**WELWYN HATFIELD BOROUGH COUNCIL
EXECUTIVE DIRECTOR - PLANNING, PUBLIC PROTECTION AND GOVERNANCE**

Application No: 6/2022/0837/ADV
Location: Cote Brasserie 1-3 Howardsgate Welwyn Garden City AL8 6AL
Proposal: Installation of 2 sets of externally illuminated fascia text signs and 2 externally illuminated projection signs
Officer: Ms Emily Stainer

6/2022/0837/ADV

Proposed Signs

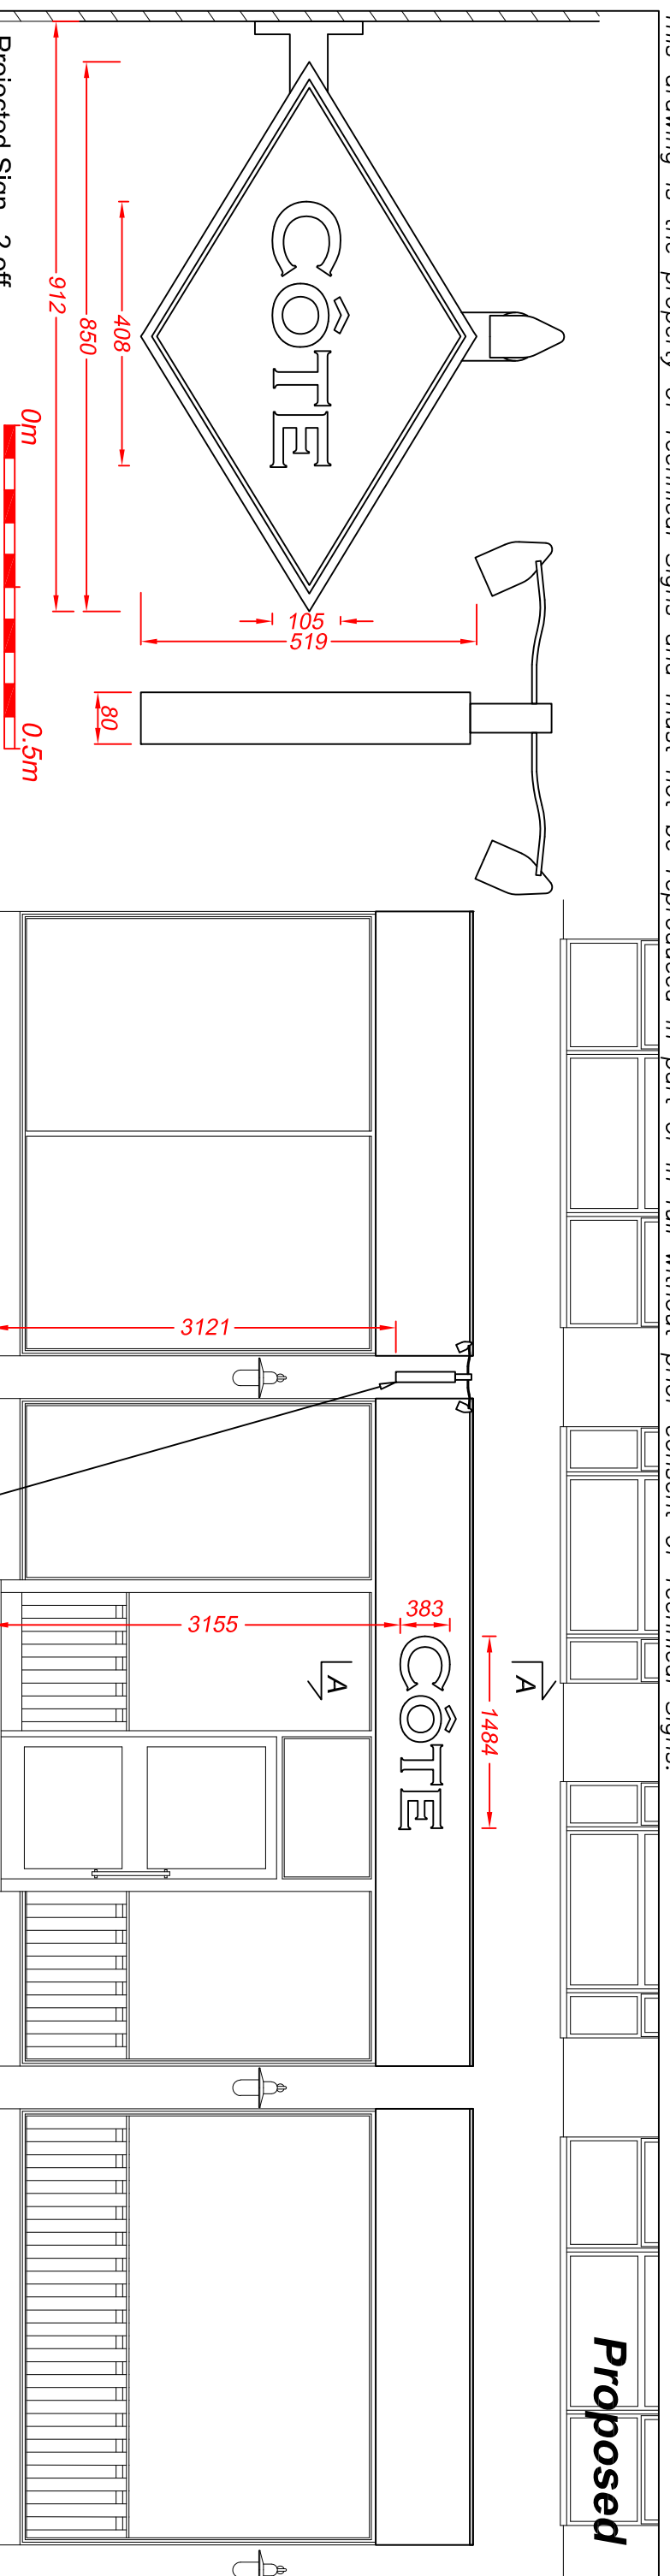
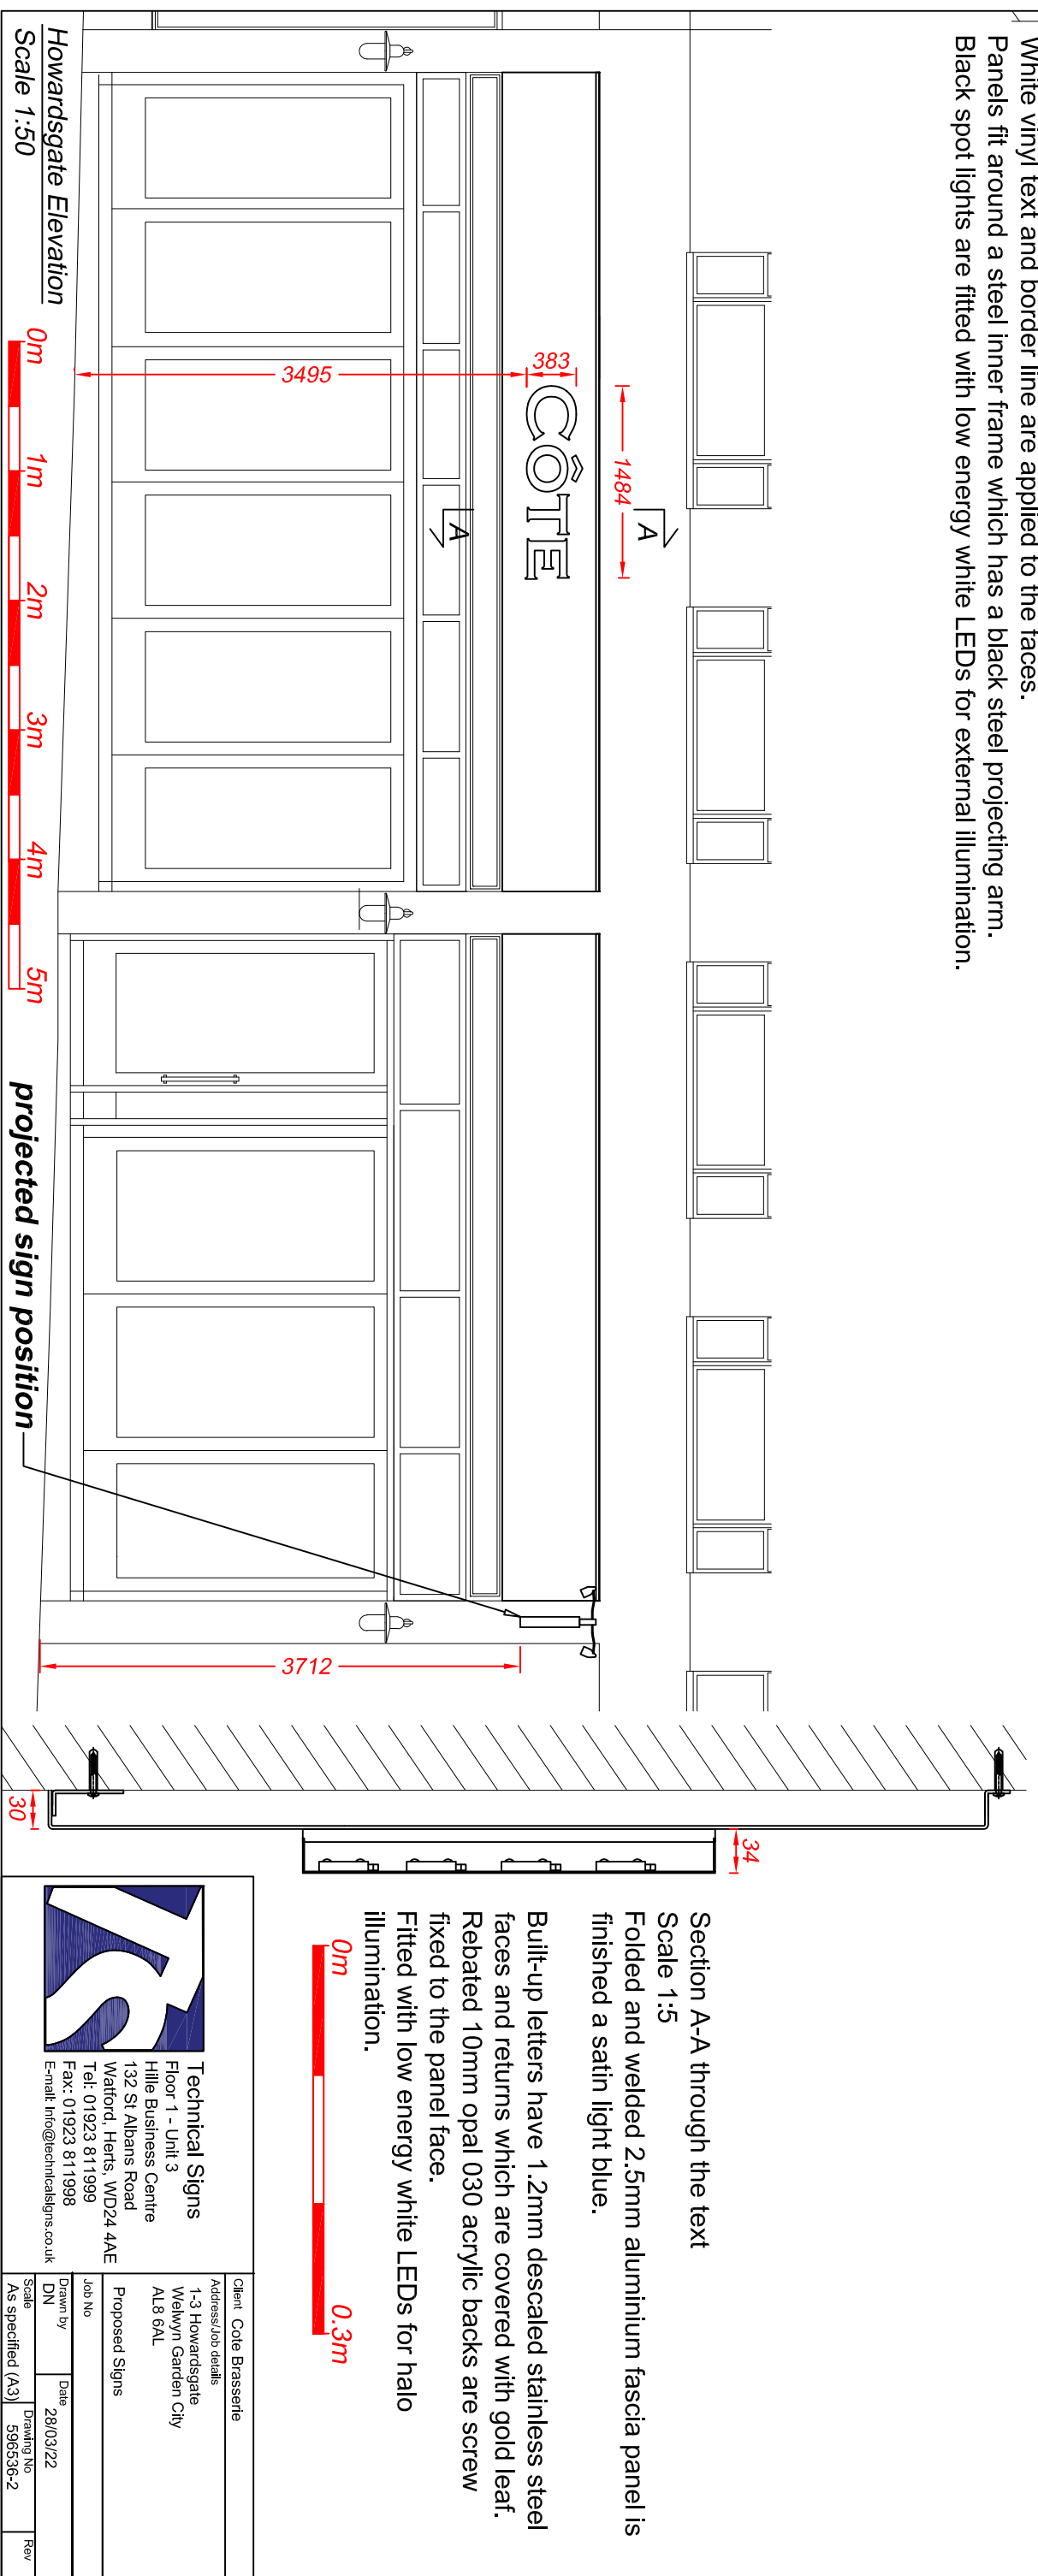
| Consultees and responses | <p>HCC Transport Programmes & Strategy - The highway authority previously responded to this application on 22 April and raised no objections. The proposed halo illumination of the fascia signs has now been changed to trough lighting. The proposed trough lights are just under 4m above the footway so will not present a danger to pedestrians. The highway authority otherwise refers to its previous response (which stated the highway authority did not wish to restrict the approval of this application subject to the inclusion of the condition and informatives listed).</p> <p>The Gardens Trust - On the basis of the information in this application we have no objection to the new-style of signage but are concerned about the bright blue as shown in the photographs. If this is the true colour proposed we consider that something more muted would fit better with the overall design of this important town centre junction.</p> <p>Place Services Conservation Officer - Previous comments stated that there were no objections to the proposed signage, but it was recommended that the internal illumination of the main sign was omitted. An amendment has been submitted that now proposes external lighting for the main sign. This is considered acceptable. The proposals are now in line with Section 72(1) of the Planning (Listed Buildings and Conservation Areas) Act 1990 and Chapter 16 the NPPF.</p> | | |

The Council's Conservation Officer reviewed the original proposal and whilst no objections were raised, noted that it was recommended the internal illumination of the main sign was omitted because the Welwyn Garden City Conservation Appraisal (September 2007) states that internally illuminated signs and excessive lighting can detract from the character of the Conservation Area. The internally illuminated sign alongside the external illumination of the hanging sign was considered to lead to excessive lighting which would not be sympathetic to the building or the appearance of the Conservation Area. Following these comments, the agent submitted a revised plan which omitted the internal lighting in the sign and the Conservation Officer has now confirmed this renders the proposal acceptable.

The Gardens Trust have commented that they have no objection to the new-style of signage but are concerned about the bright blue as shown in the photographs as something more muted would fit better with the overall design of this important town centre junction. It is unclear if this relates to the colour of the signage or the front of the premises. It is considered the satin dark blue and satin light blue colour on the proposed projecting signs is acceptable in design terms. As this application relates to the proposed signage only and not the other elements of the exterior of the building, an informative will be added advising the applicant that although advertisement consent is granted, if any further works require planning permission they will require a separate application.
